DRB Application No.: **04DRB-01686 (P&F)**

Project # **1002702**

Project Name: **Iron Properties**

OFFICIAL NOTICE OF DECISION

STATE OF NEW MEXICO) S.S.
COUNTY OF BERNALILLO)
THIS INSTRUMENT WAS ACKNOWLEDGED BEFORE ME A NOTARY PUBLIC THIS 11th DAY OF November, 2004
By: [Signature]
OWNERS NAME
MY COMMISSION EXPIRES: 10/06/2008 BY: [Signature]
NOTARY PUBLIC

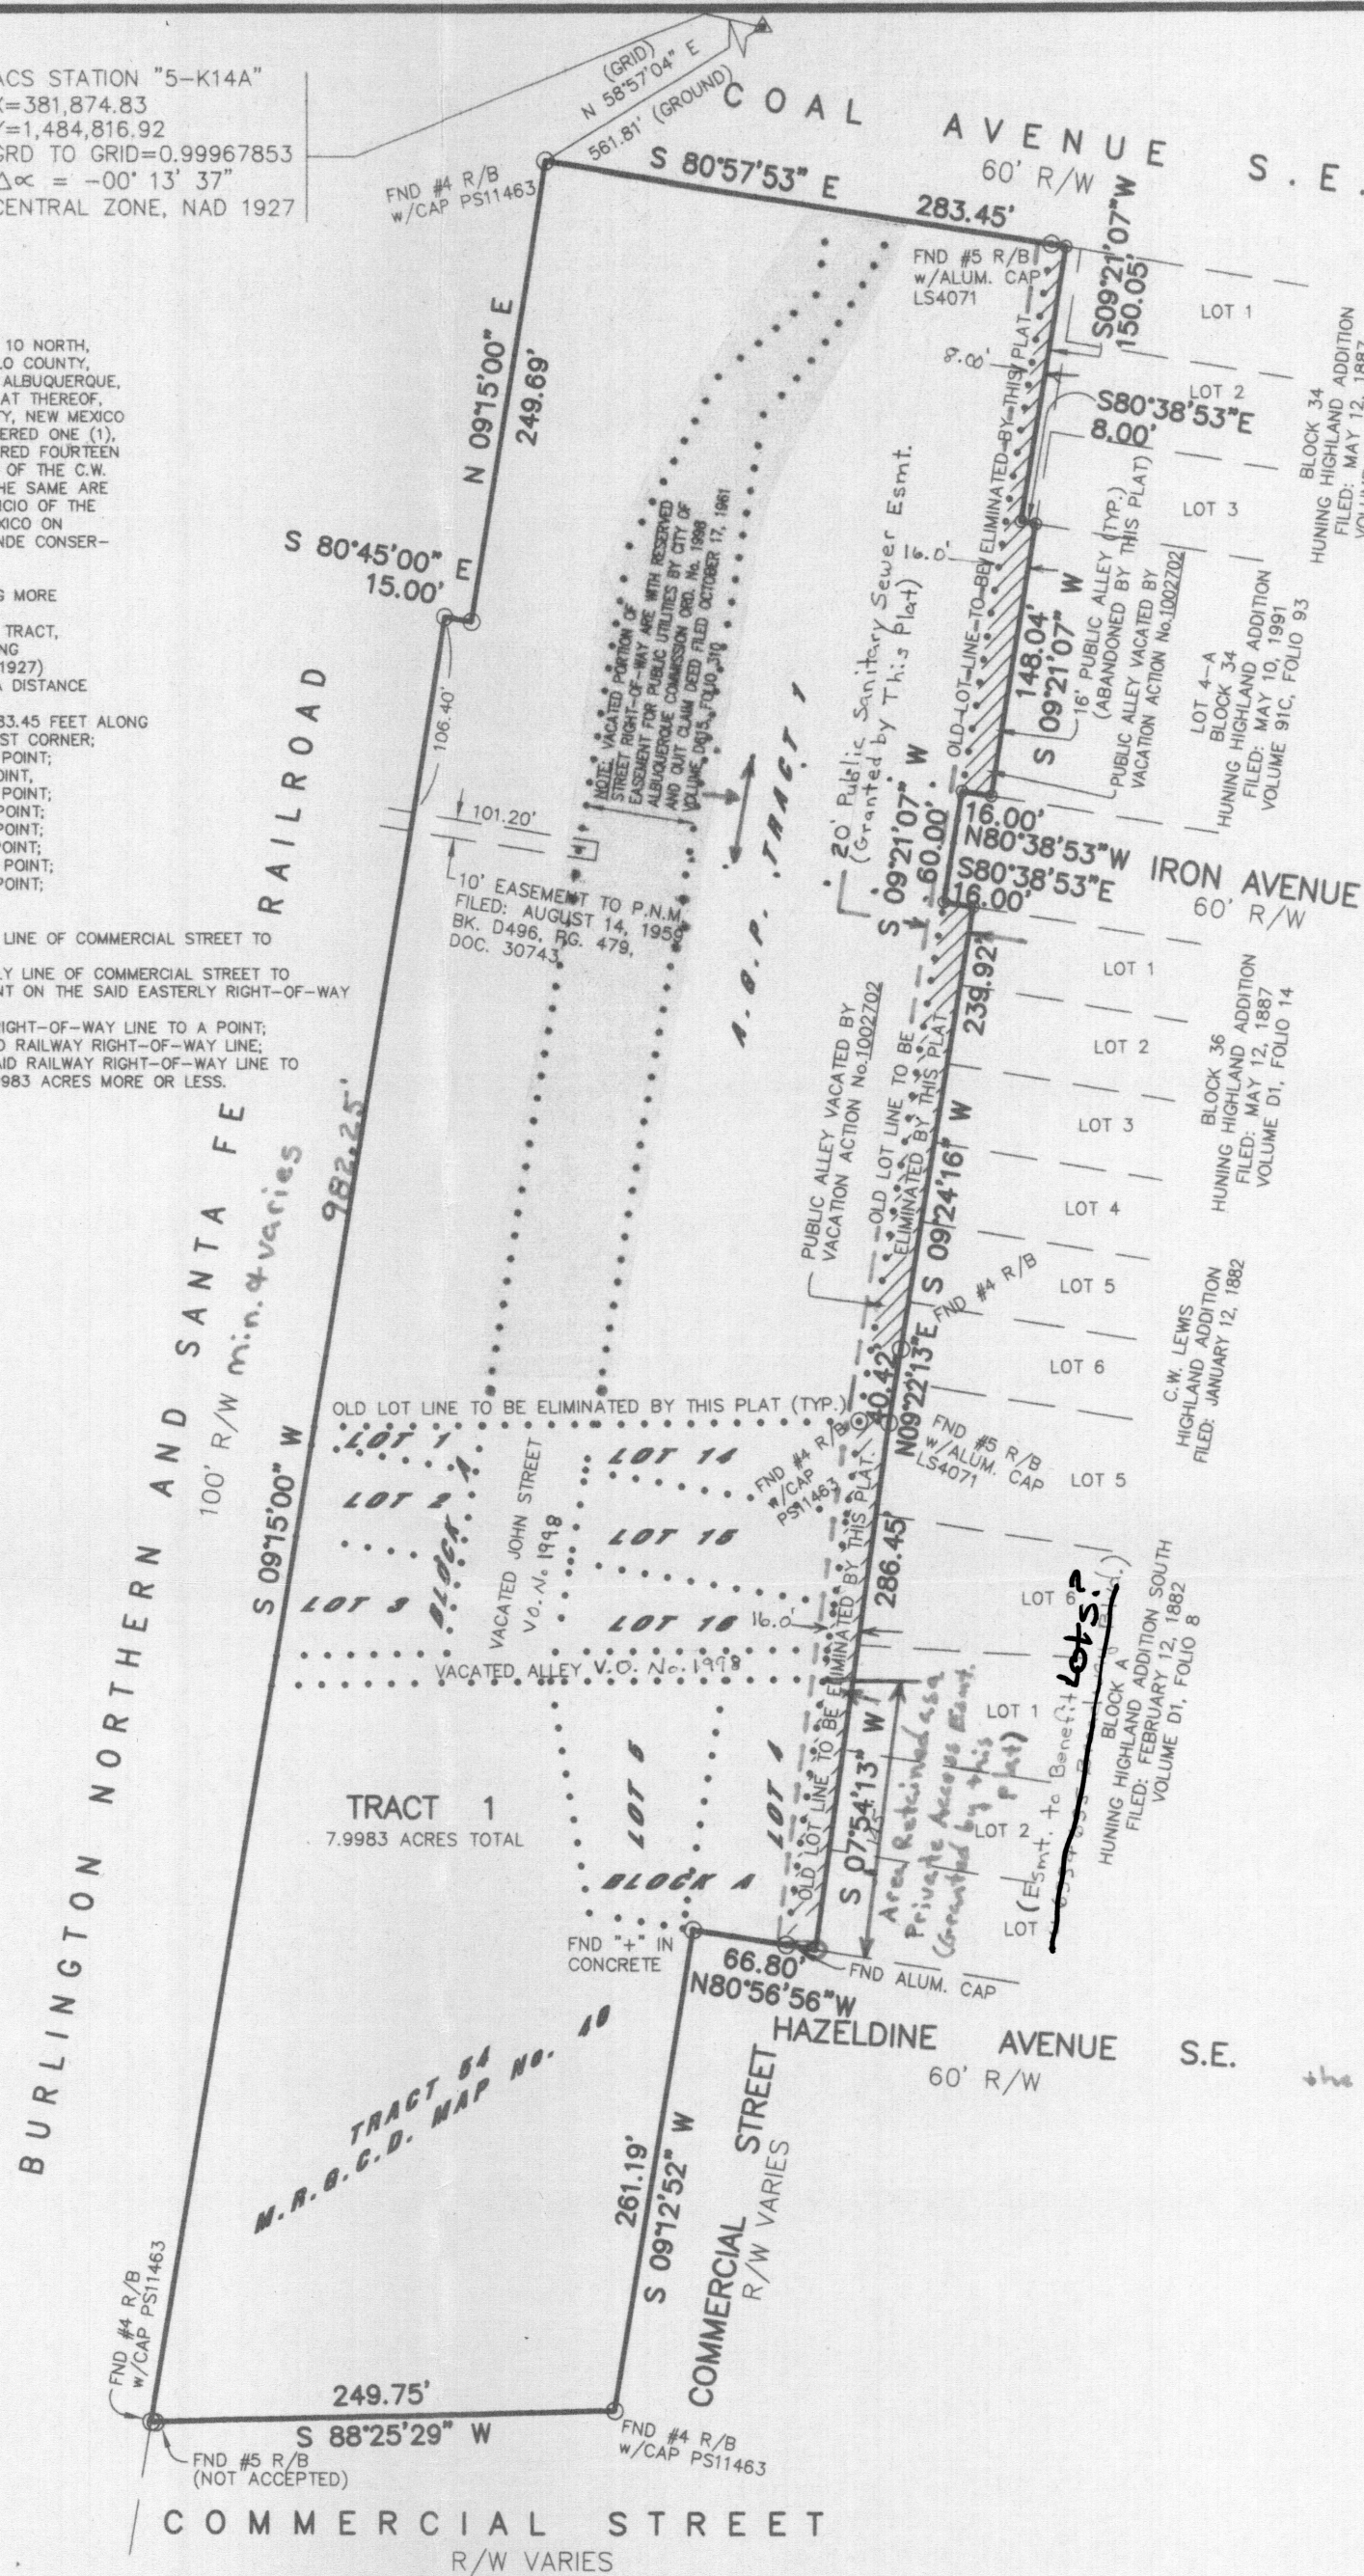
At the June 26, 2003 DRB hearing where this vacation was previously approved, applicant agreed to keep the portion of the north/south alley open between Hazeldine and the east/west alley as a result of adjacent property owners comments at the hearing. The plat does not appear to reflect this agreement.

In addition, these conditions of vacation were imposed: (1) an exhibit showing the location of the alley fencing is required at the time of plat approval; (2) the retention of adequate easements ~~for storm drain~~ and other utilities; (3) a survey showing the relation between the existing manholes and water meters, the alley and other utilities.

The plat shows "vacated John Street" and "Vacated Alley" in the middle section of the plat. A reference to the vacation action is needed. The public alley vacation action needs the Application number as well.

The Hydrology Section has no objection to the vacation request.
Need public easement for existing storm drain.

PNM has overhead facilities with the alley to be vacated. PNM will require
access and easements to maintain these facilities. Vacation OK if an
easement is granted to maintain facilities.

No objection to the vacation request. Plat must provide easements for public storm drain or owner must maintain onsite storm drain.

Where is the private access easement to 633 & 635 Broadway from Hazeldine? This was a condition of final plat. Provide exhibit relating addresses to lot numbers.

- a new 20' wide public sanitary sewer easement must be granted for the existing sanitary sewer line in the alley to be vacated. The Plat is not acceptable. It does not show the required easement for existing sewer line and does not show all of vacated John Street with utility easements that may have been retained. Need to see copy of Vacation Ordinance that vacated John Street.
